Our reference: DOC12/33459  
Our contact: Benn Treharne, 9995 6807

**EPA response to public exhibition of the Environmental Impact Statement for the Horsley Drive Business Park (SSD 5169)**

### EPA comments and recommendations on the EIS for the Horsley Drive Business Park

**EROSION & SEDIMENT CONTROL PLAN**  
1:2000

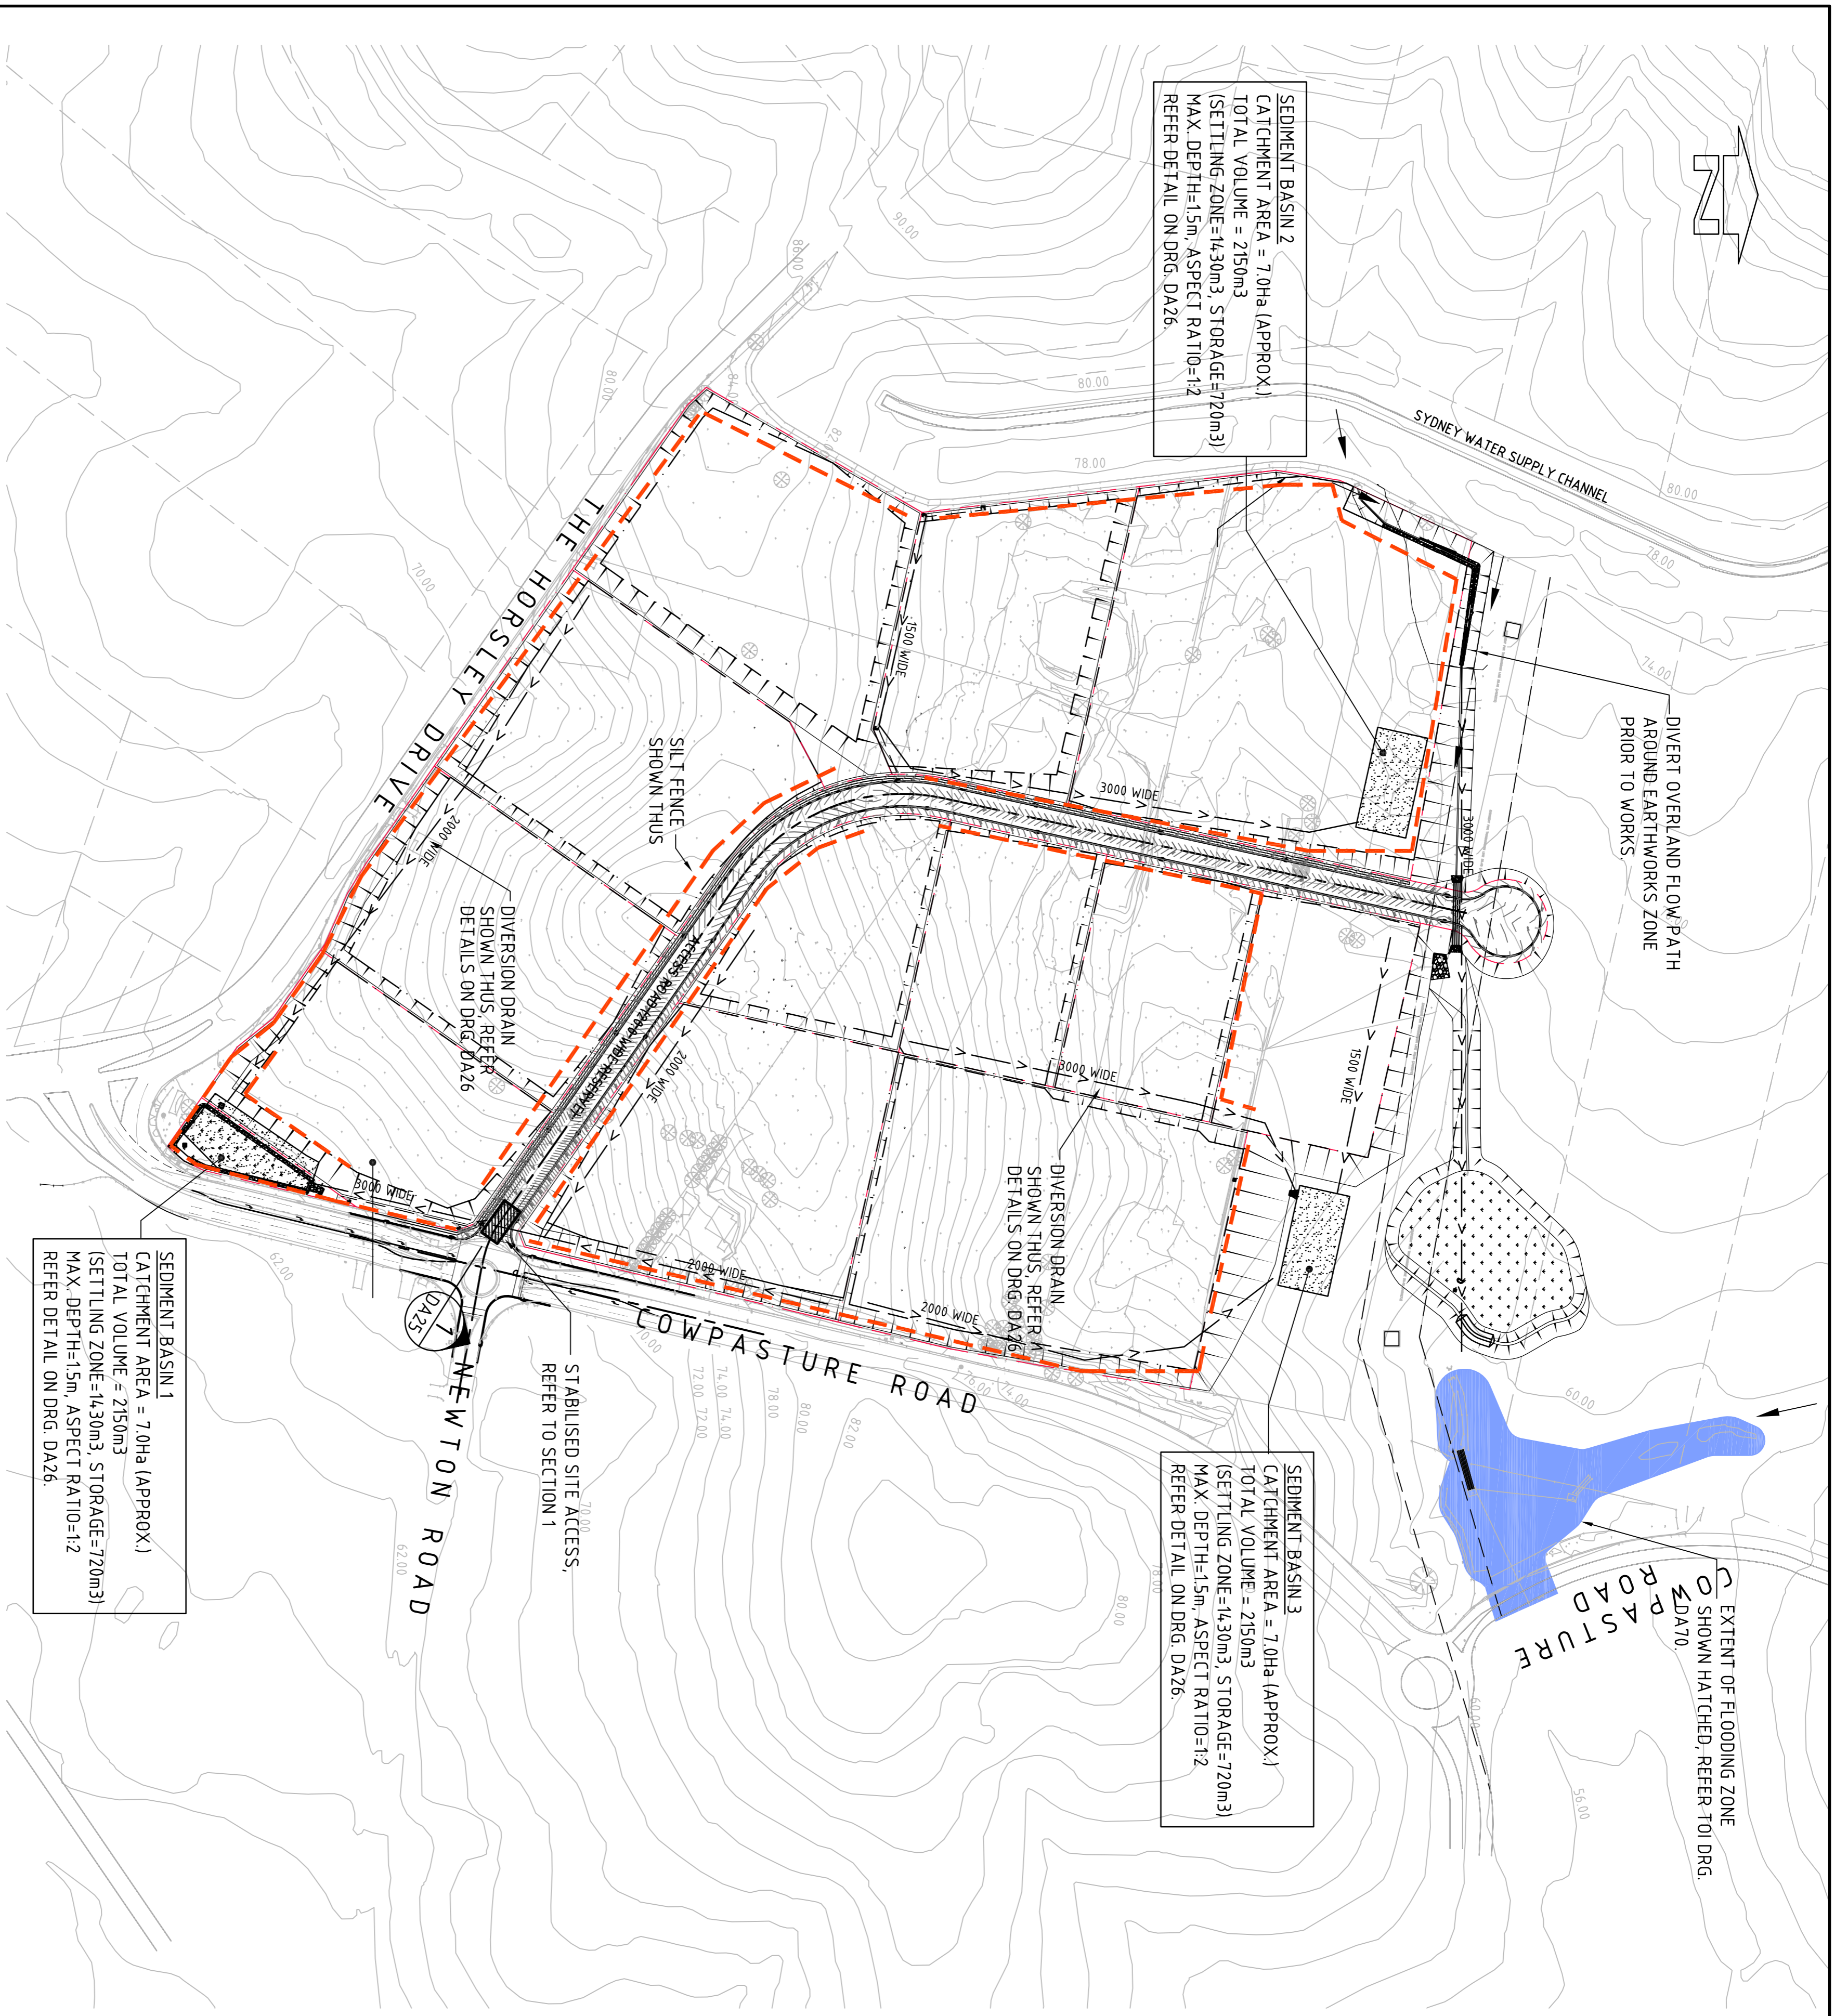
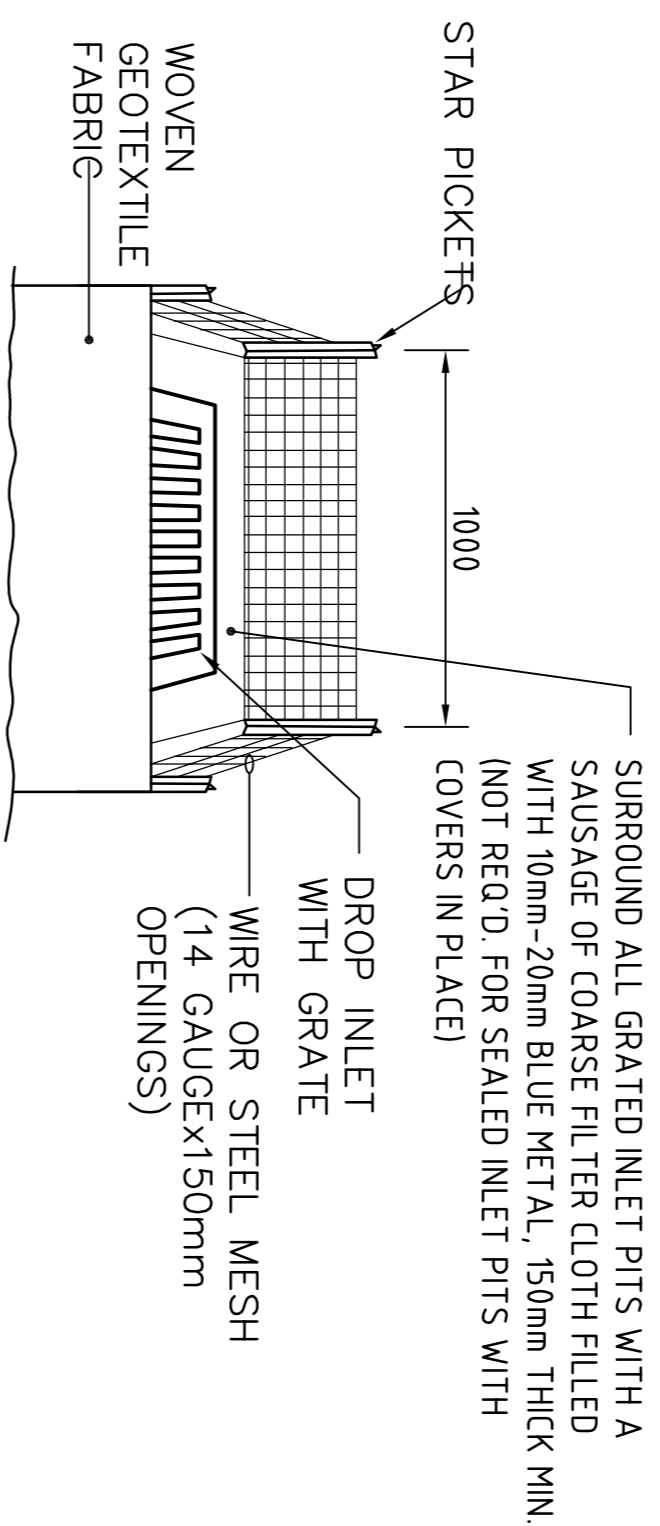
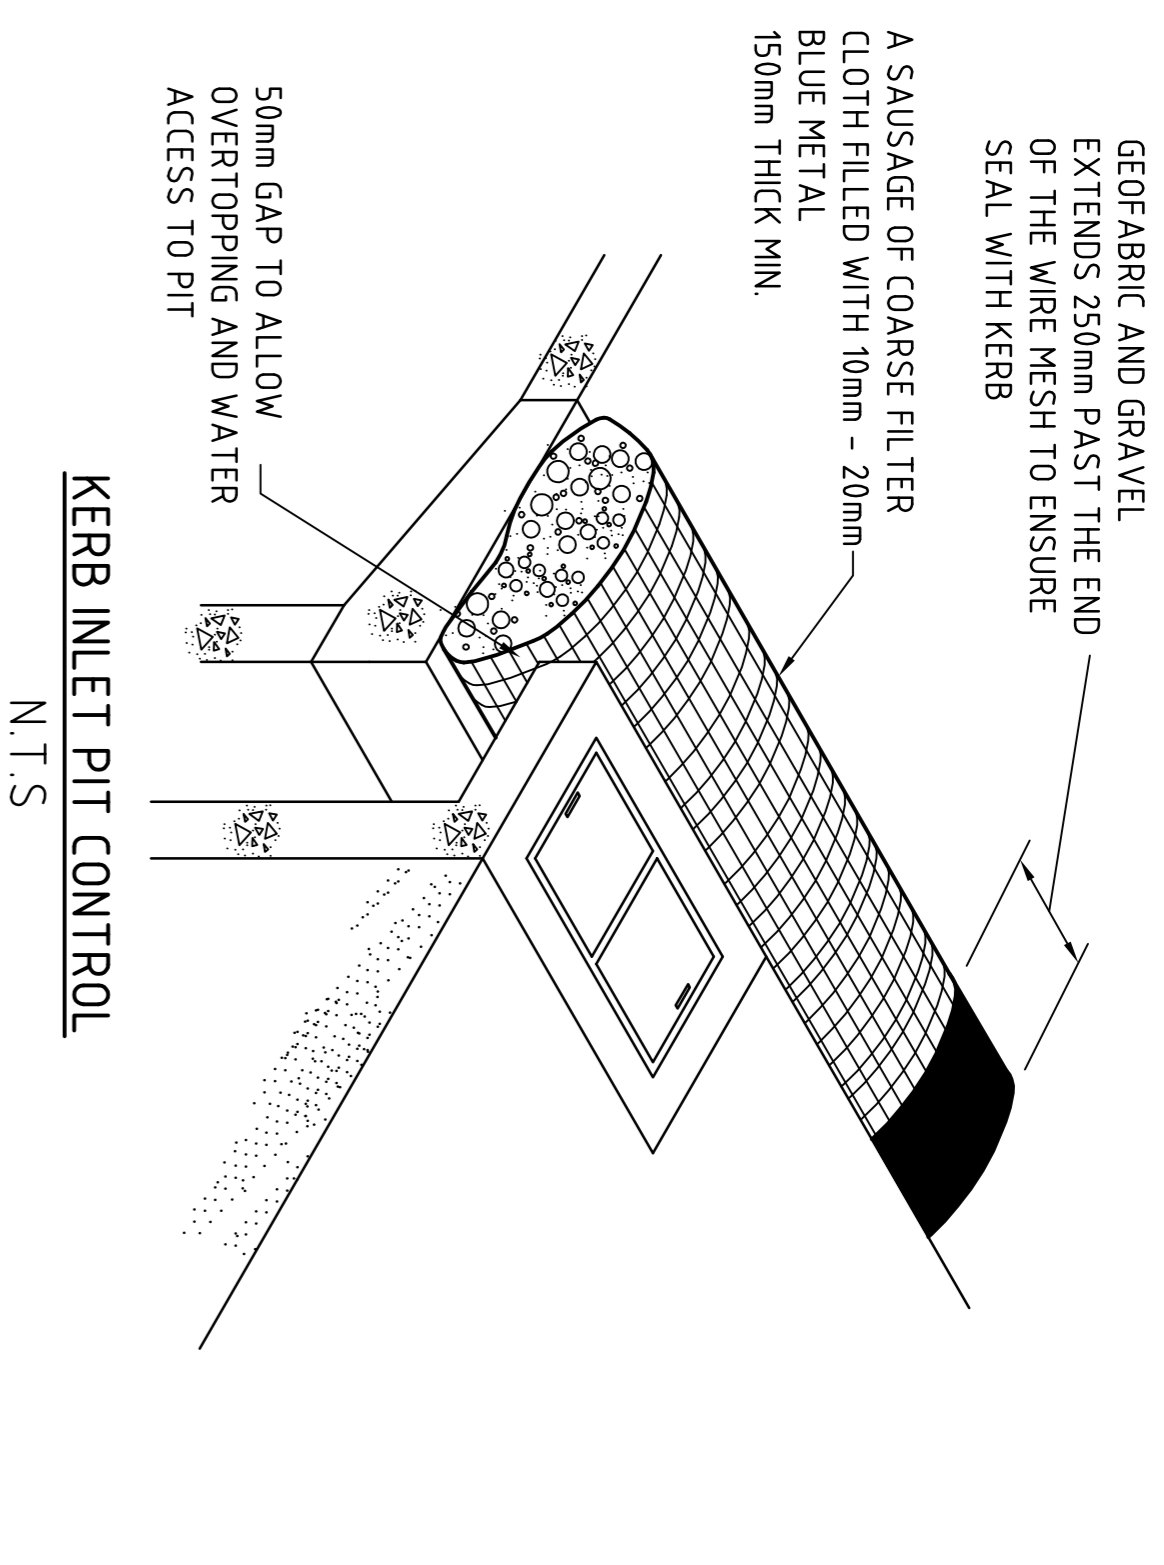
The EPA notes that this proposal has the potential to cause significant erosion and sedimentation issues due to the extensive excavation required to achieve level building platforms on the naturally undulating topography of the site. The EPA acknowledges that an *Erosion and Sediment Control Plan* (Costin Roe Consulting) has been prepared to address these issues, however it is noted that this plan is conceptual only and that a detailed plan will be prepared once consent is given.

A suitably detailed and project specific Erosion and Sediment Control Plan must be developed and implemented as per *Managing Urban Stormwater: Soils and Construction - Volume 1*, Landcom, 4<sup>th</sup> ed. 2004 prior to commencement of any works involving vegetation removal or soil disturbance
